Planning Officer: Ms Myer

Planning Application Ref: BN/22/20/PL

Location: Land South West of 40 Hill Lane, Barnham, PO22 0BL

Description of works: Removal of existing polytunnels & creation of sand school with new native tree & hedge planting

Drawing No. DPA-01	Revision 03
-----------------------	----------------

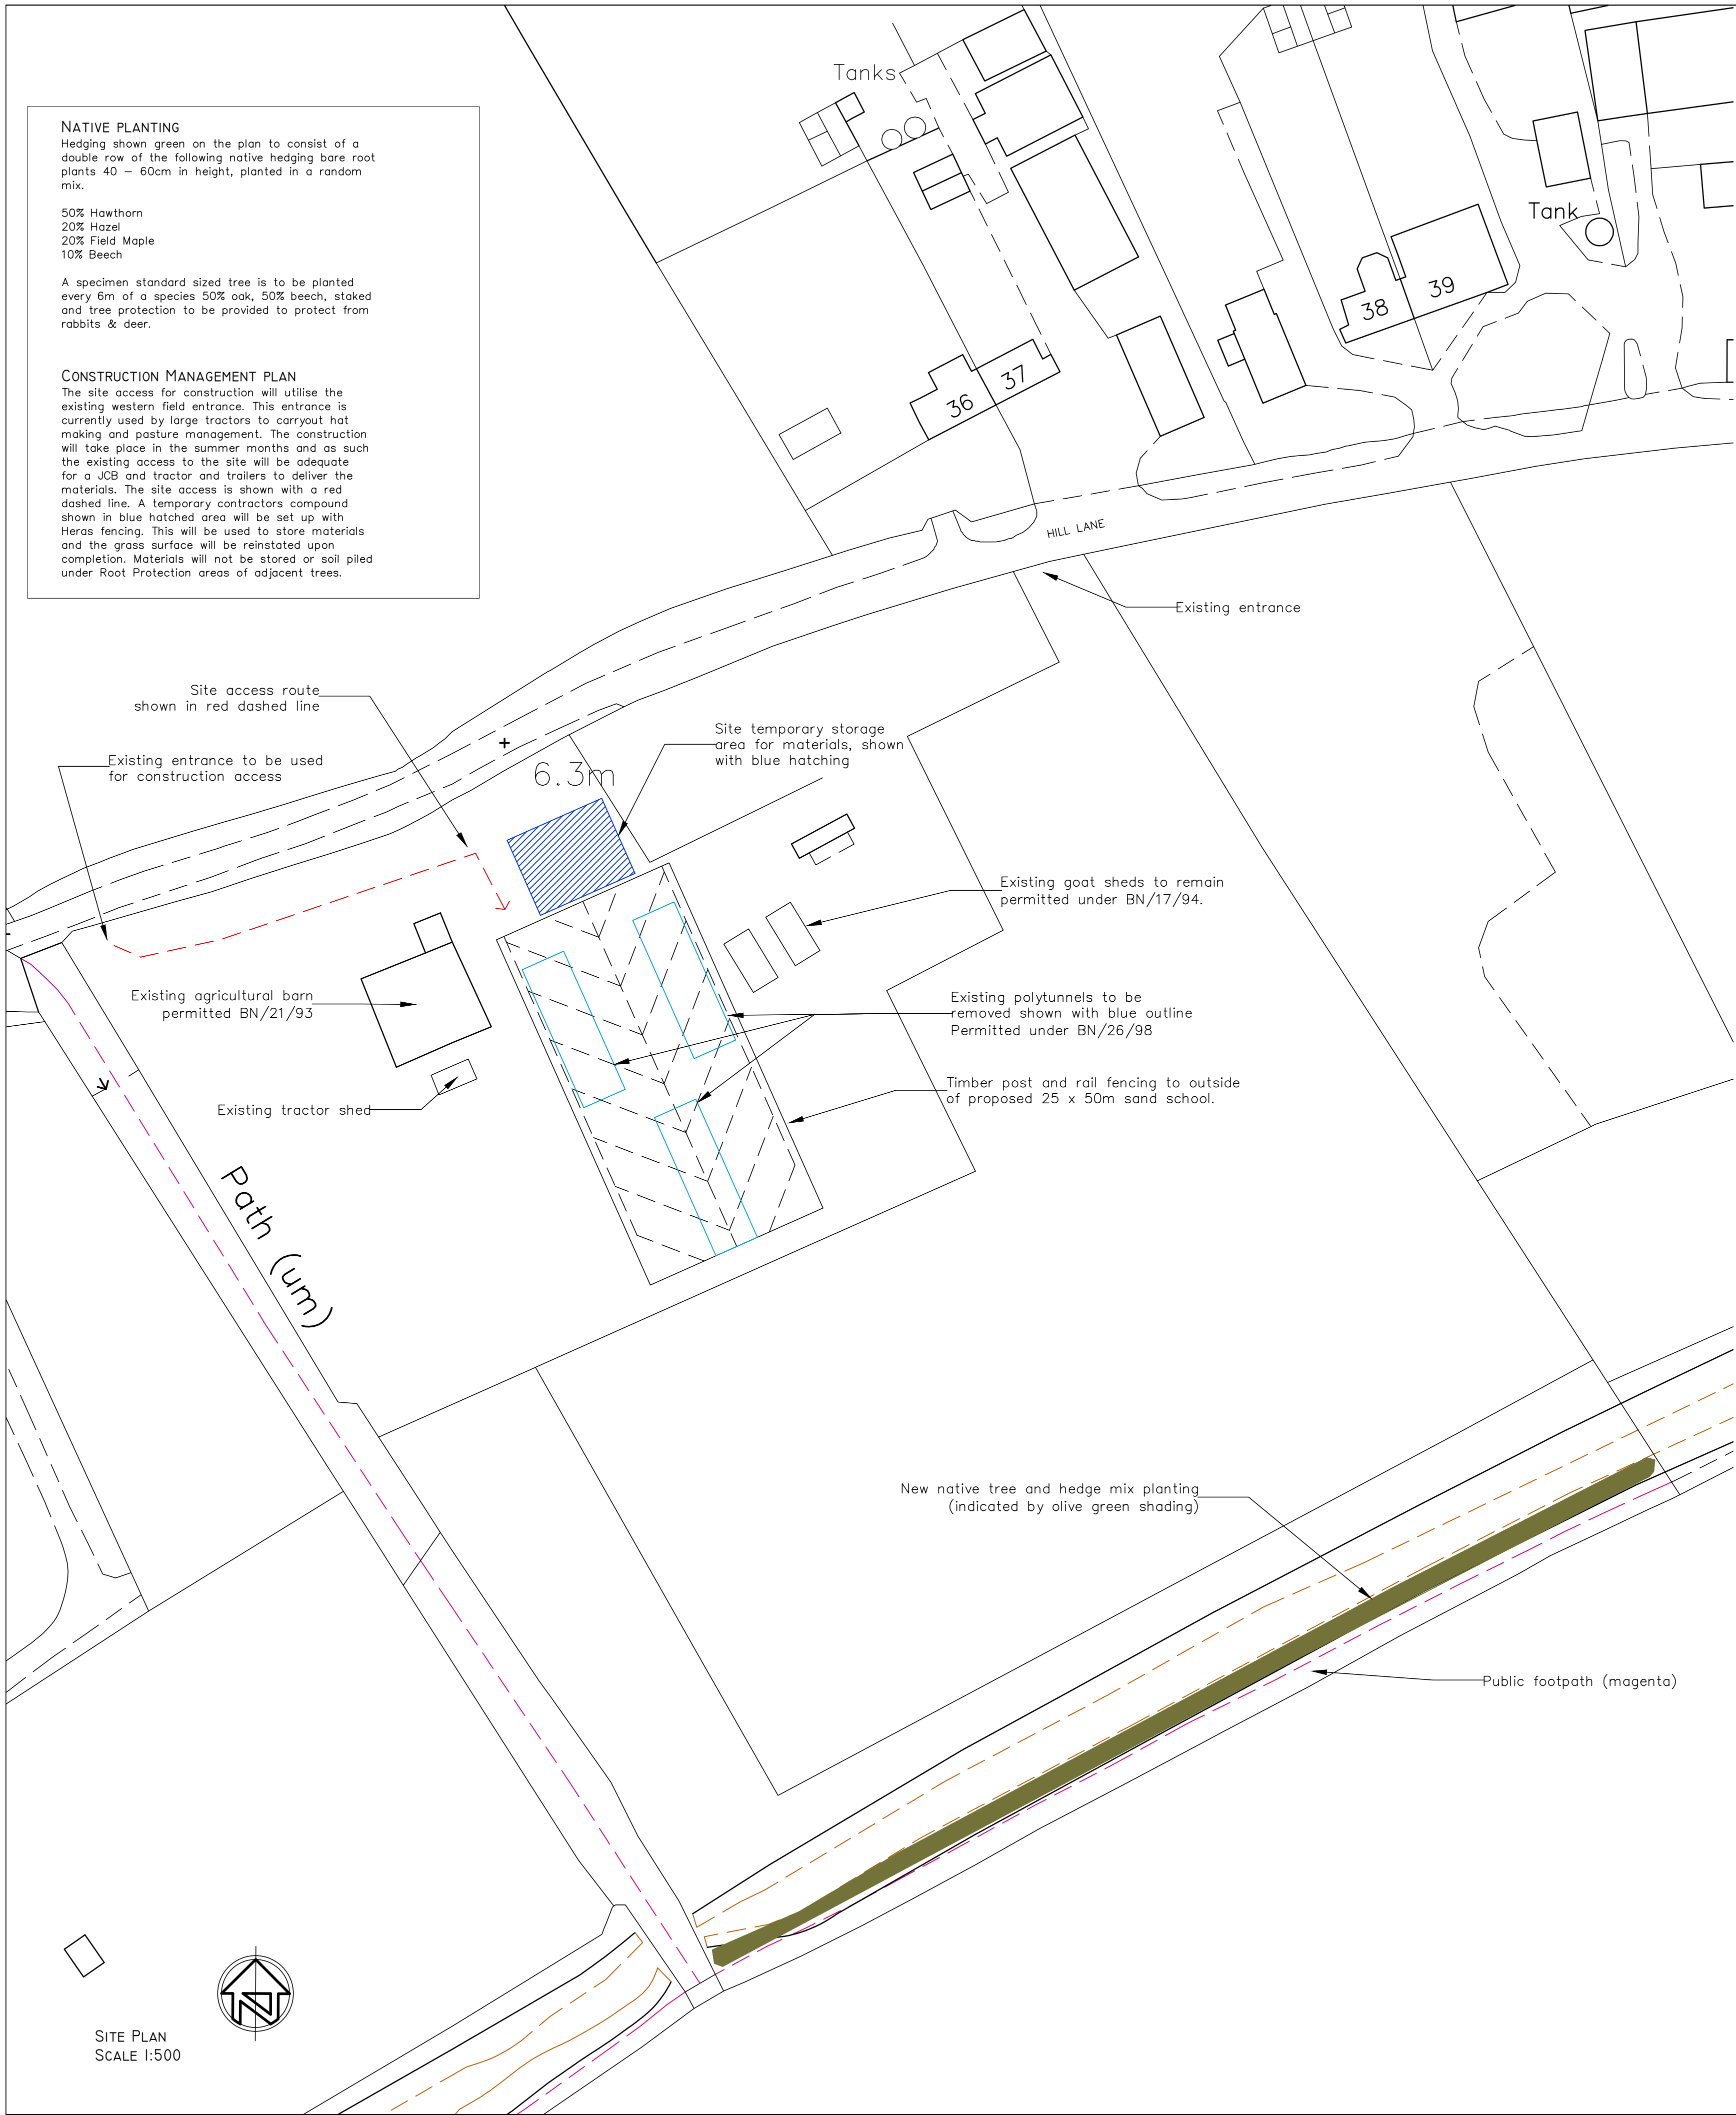
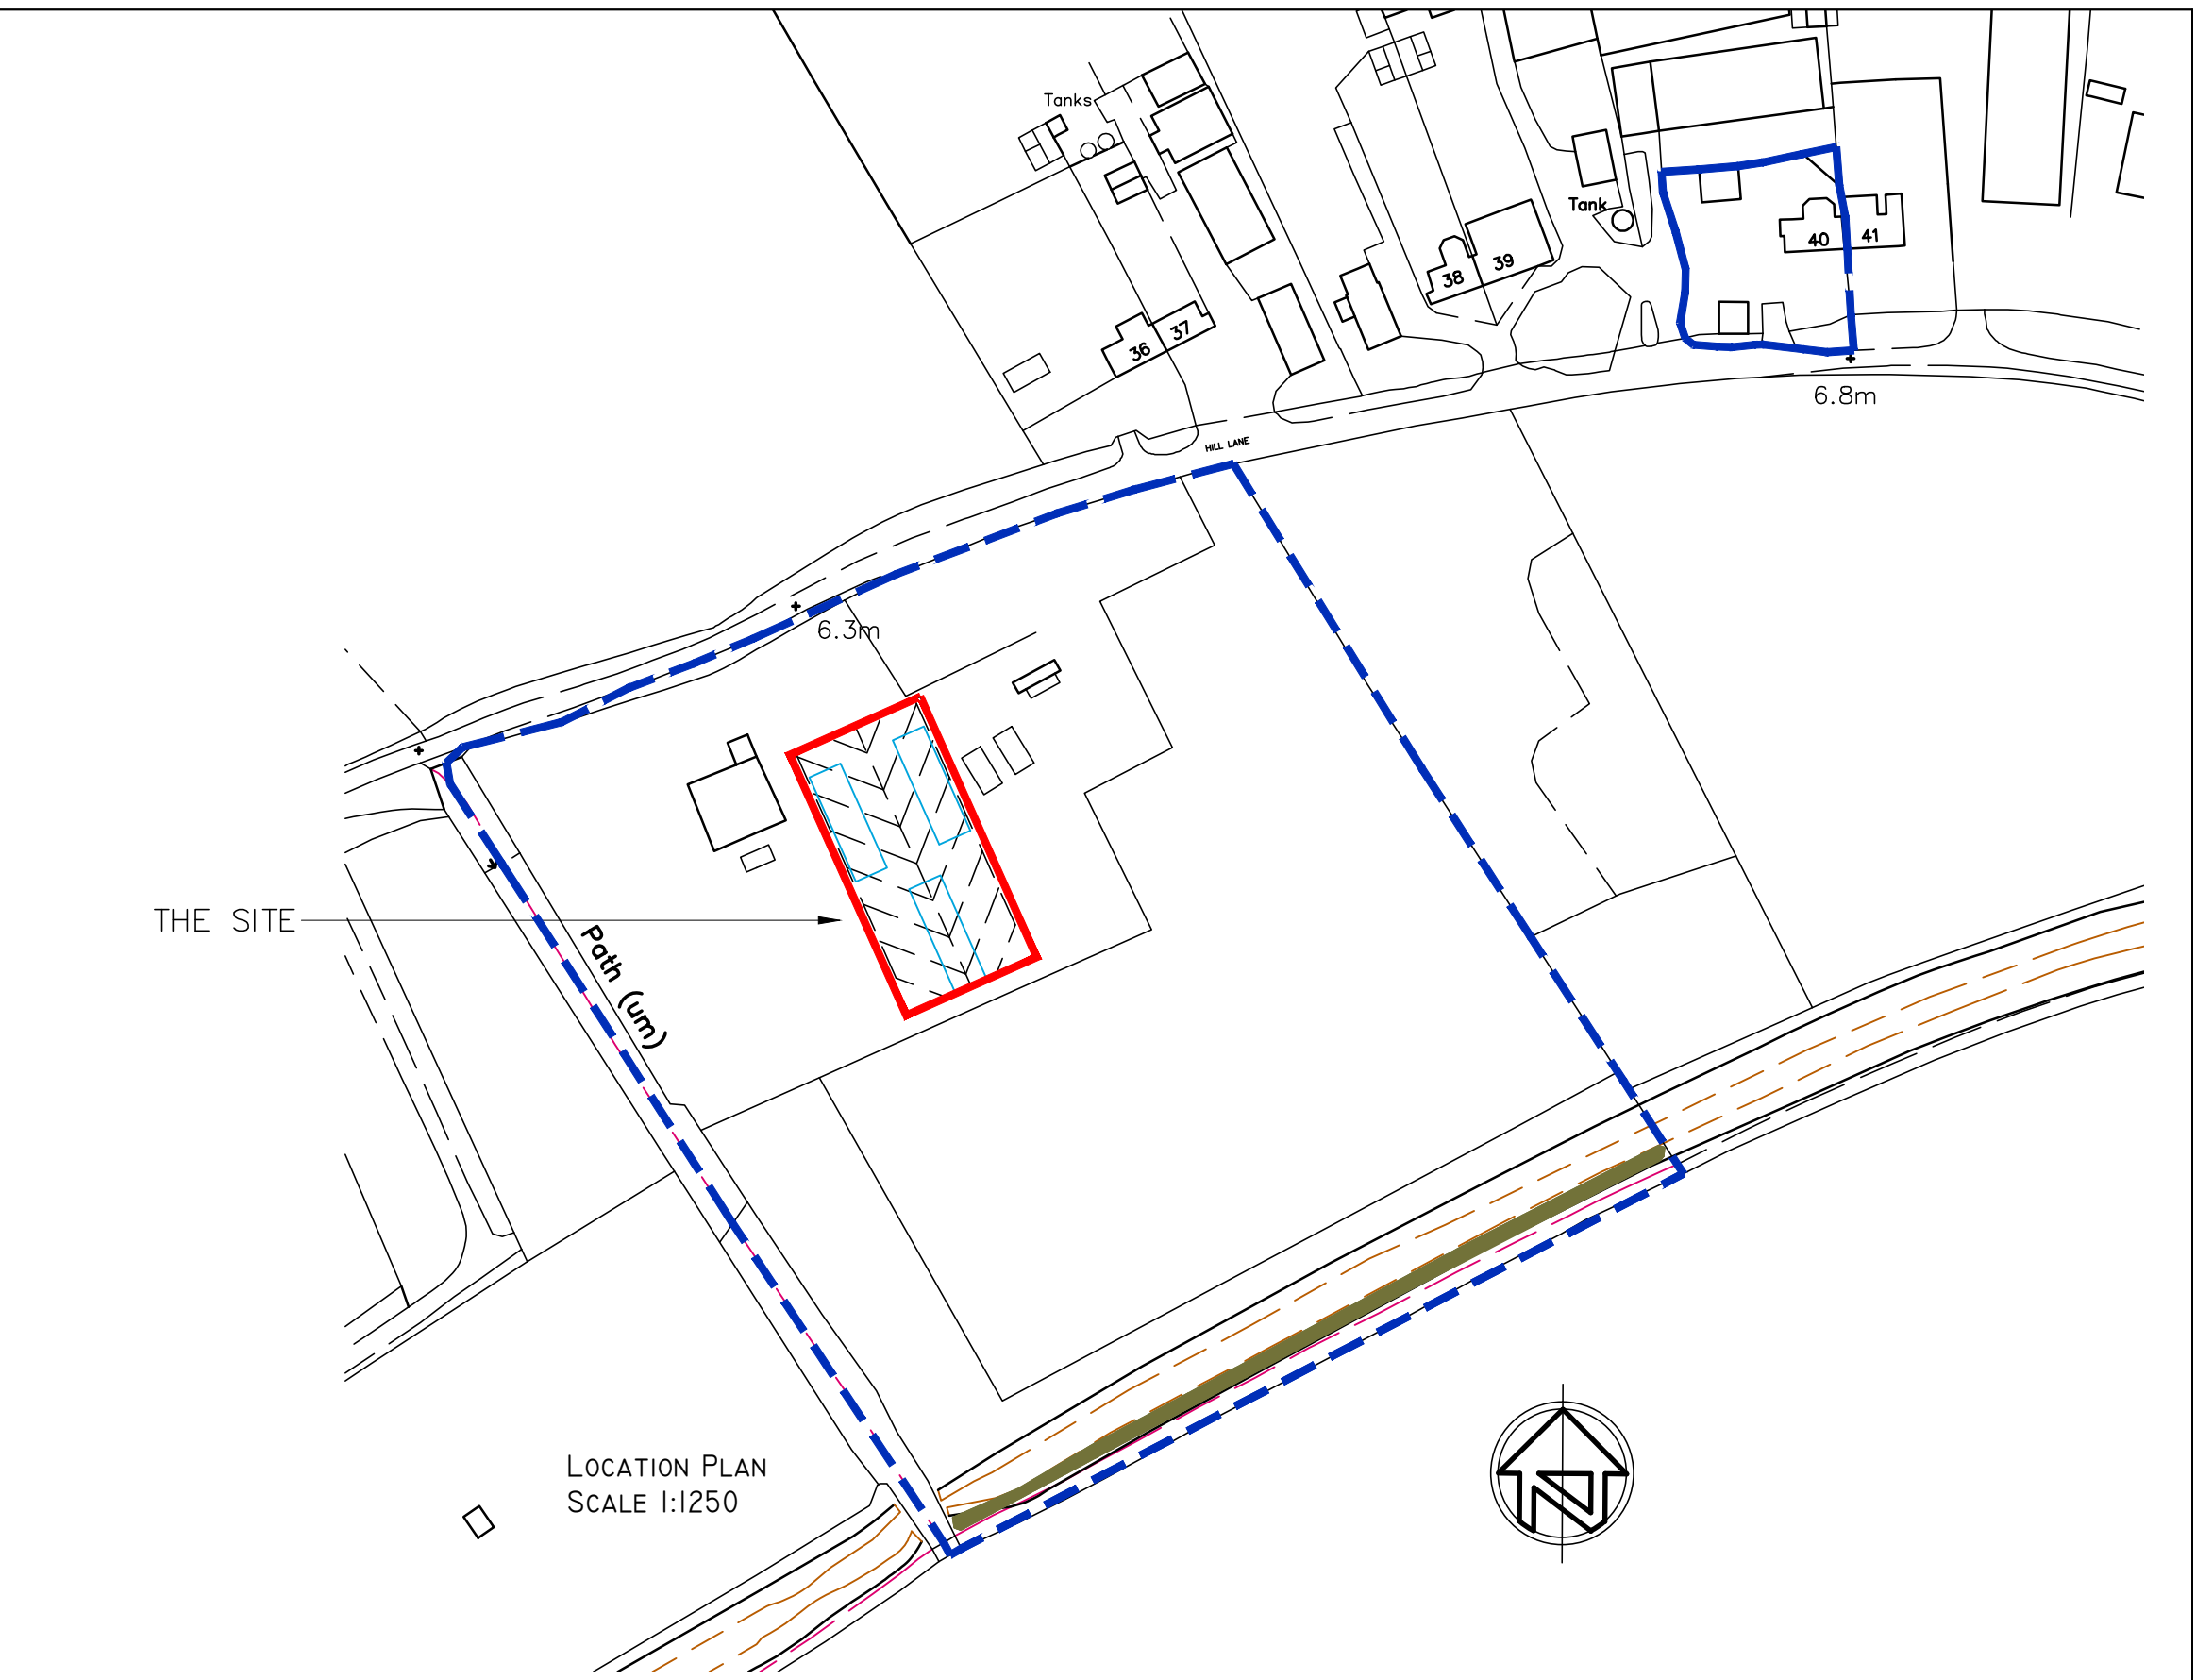
- c) Although the trees within the development appear to be of low quality, we should expect some mitigation for the loss by way of a detailed replacement planting scheme elsewhere on the plot. I see that has been proposed and support the scheme as described on the plan provided by Pope Stevens Architecture Ltd, dwg. no. DPA-01, Rev 02.

- We await confirmation of its viability along the southern boundary where attention has been drawn to potential contamination issues affecting adjacent land (Environmental Health – Consultation Response, April 2020).
Applicant or EH to advise.

- Trees selected to grow as standards within the hedgerow should not adversely affect the existing watercourse on north boundary, if planted at minimum 2m distance from the top of the ditch. **Confirmation required.**

- Online resources suggest native hedgerow exists in part along north (roadside) boundary. Is the proposed planting scheme intended to replace or enhance that feature. **Confirmation required.**
